Recommendation Report for Planning Permission for Works or Extension to a Dwelling

REF NO: P/88/20/HH

LOCATION: 48 Greenways
Pagham
PO21 4QE

PROPOSAL: Demolition of conservatory.Erection of single storey rear extension.

Drawing:
 DESIGN PROPOSALS

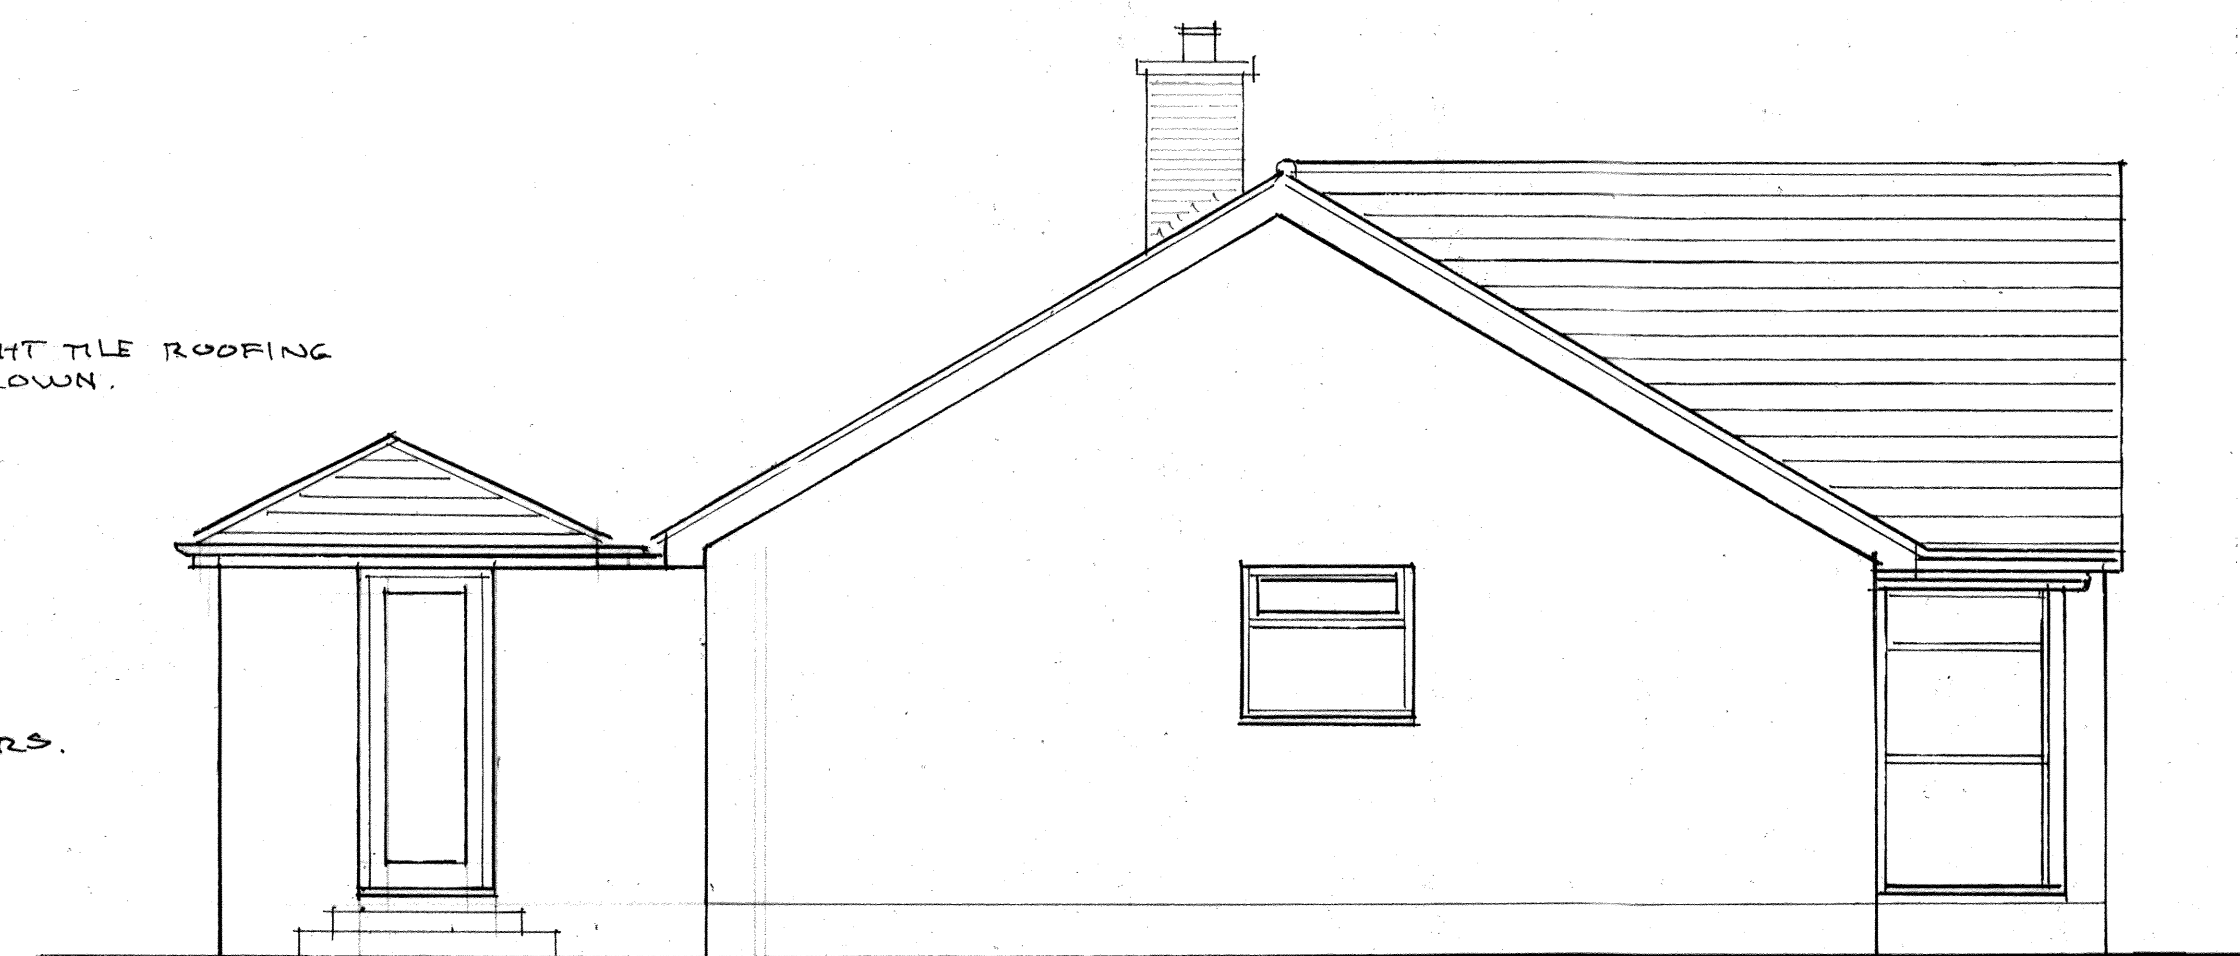
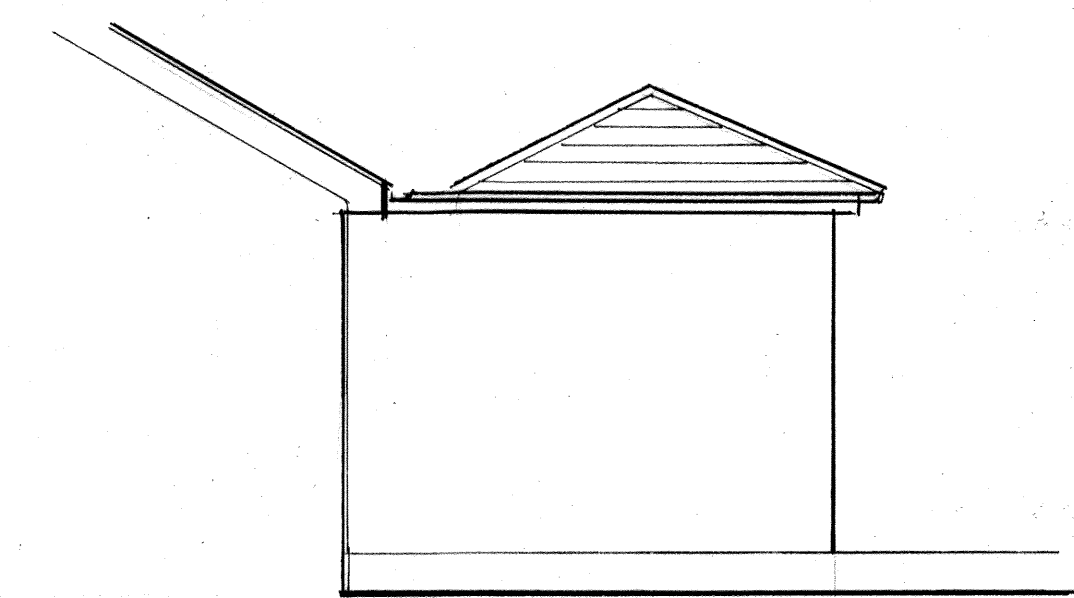
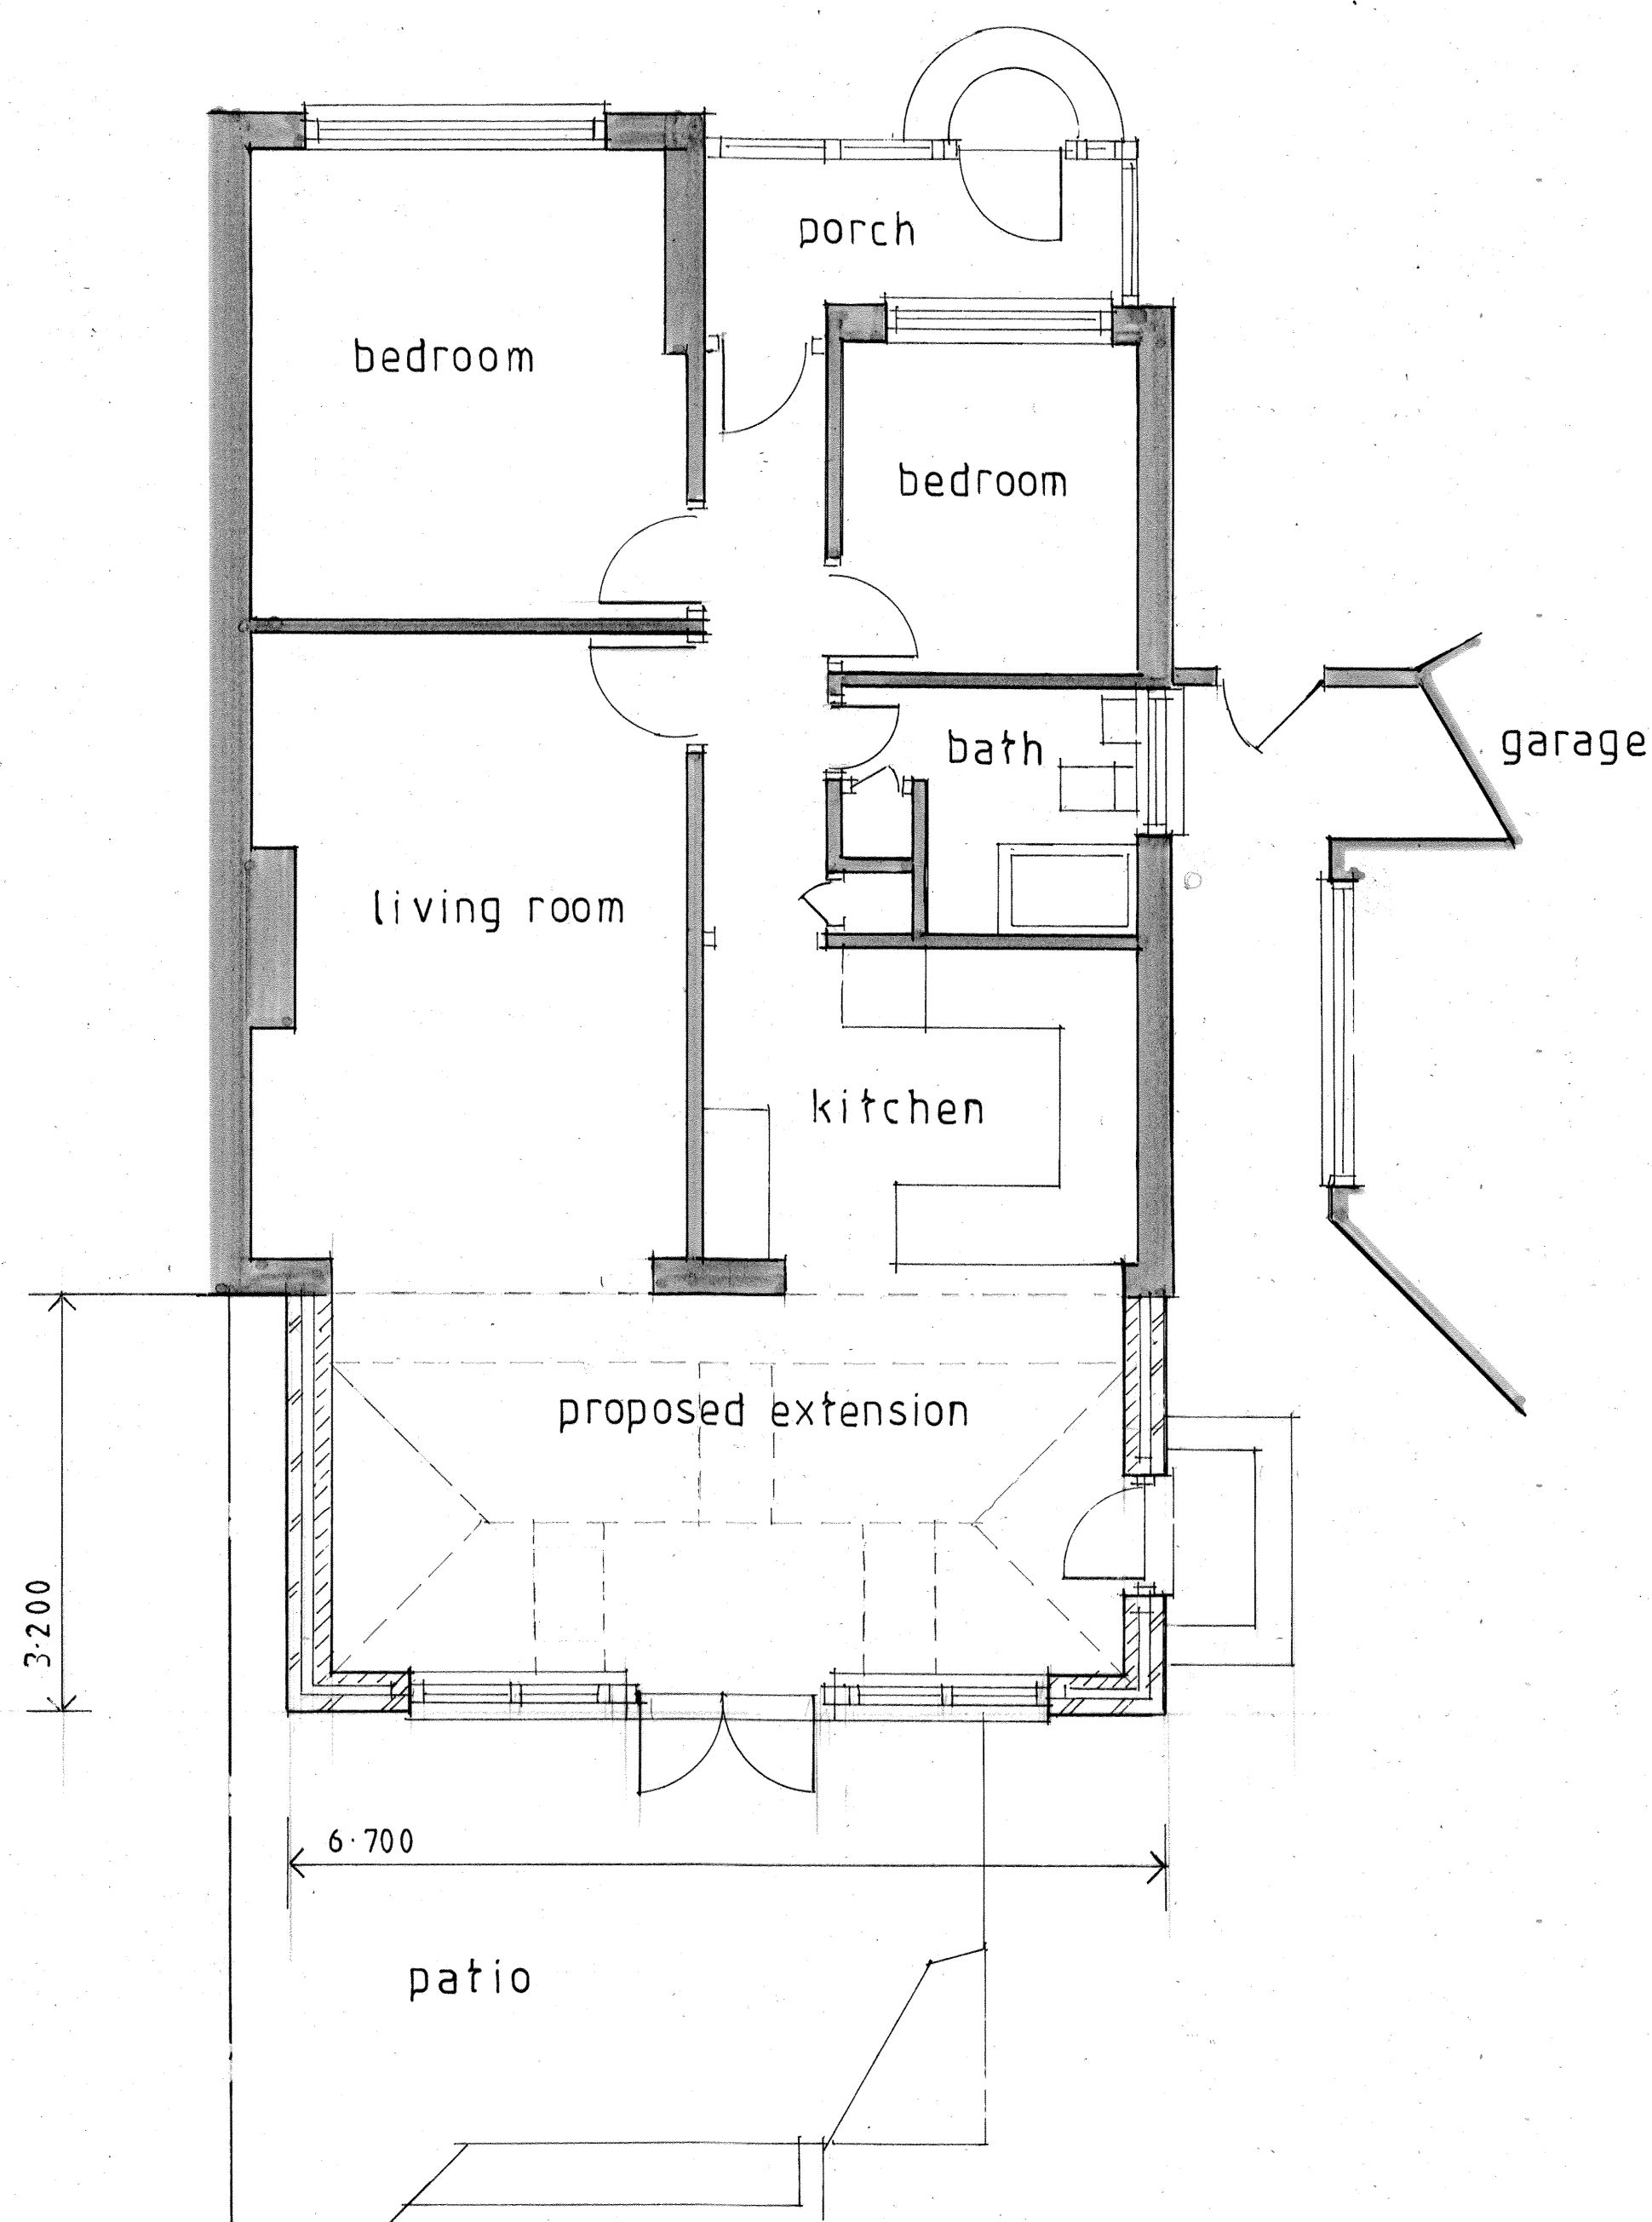
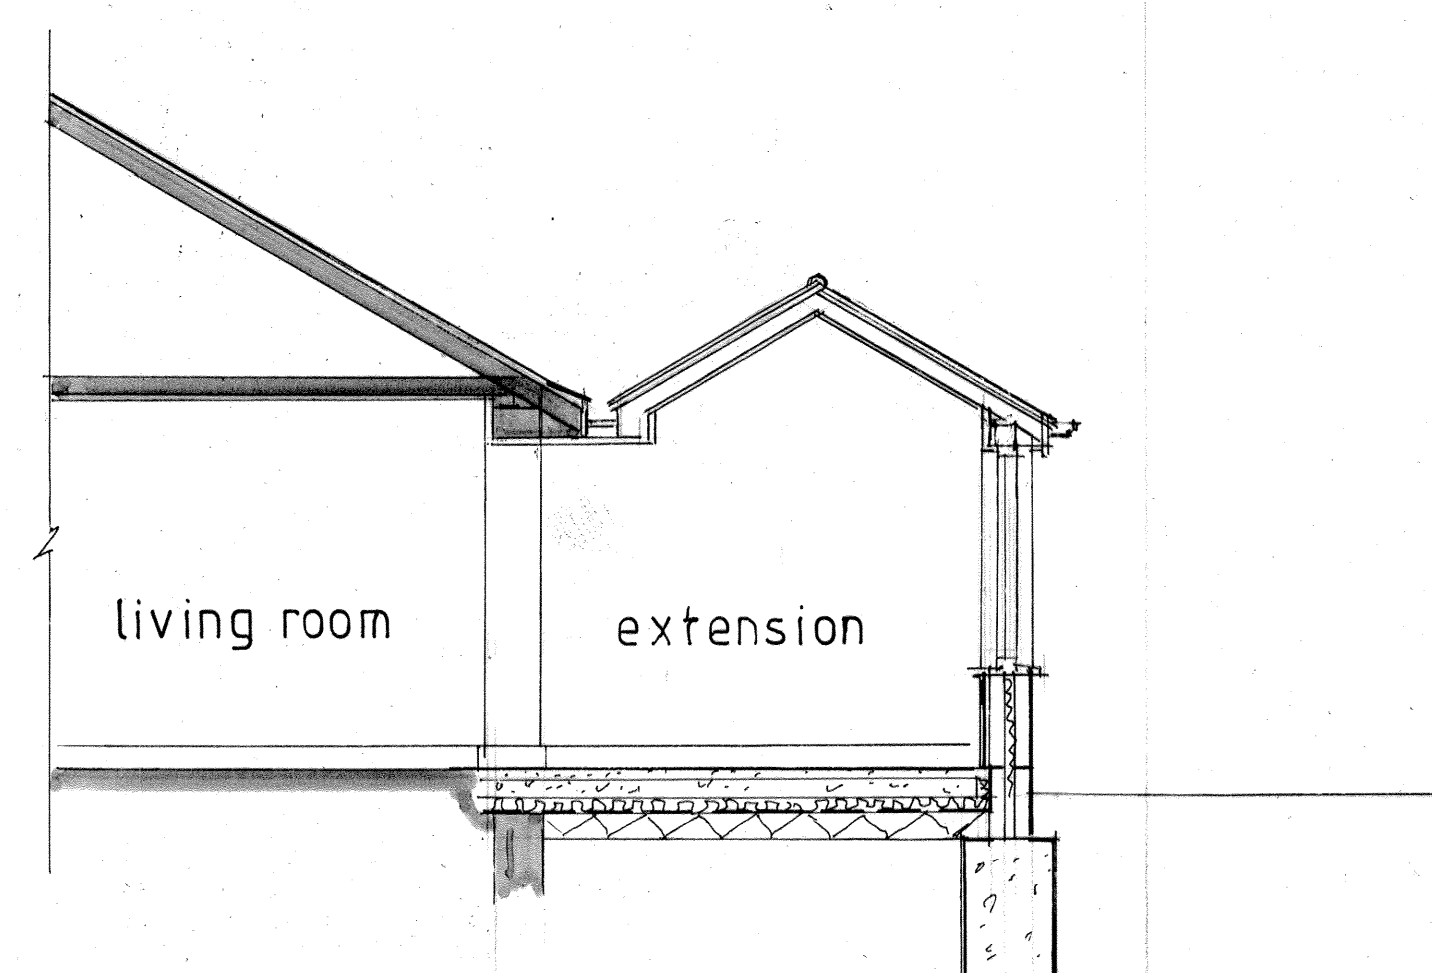
The property seeks to replace an existing conservatory on the eastern elevation with an extension of a similar footprint albeit approximately 700mm deeper.

The proposed extension will be 6.7m wide and 3.2m in depth, with a ridge height of 3.5m with eaves to match existing and will therefore appear subservient to the host dwelling. It is not deemed to adversely impact the spatial character of the local area, as such the design, siting and scale of the extension accord with the policies D DM1 and D DM4 of the Arun Local Plan.

The existing structure which is being replaced, has a mono-pitched roof which is 800mm lower than the proposed; although the overall height of the ridge at approximately 3.5m high is not considered to cause any undue harm to the neighbouring properties. It is felt there is sufficient space to the proposals respective boundaries, with no encroachment on the distances set from the previous structure on the proposals nearest boundary with No.46 to the South.

No additional views out of the building are proposed to those which is already achievable, the proposed 3No. rooflights will be located significantly above normal head height.
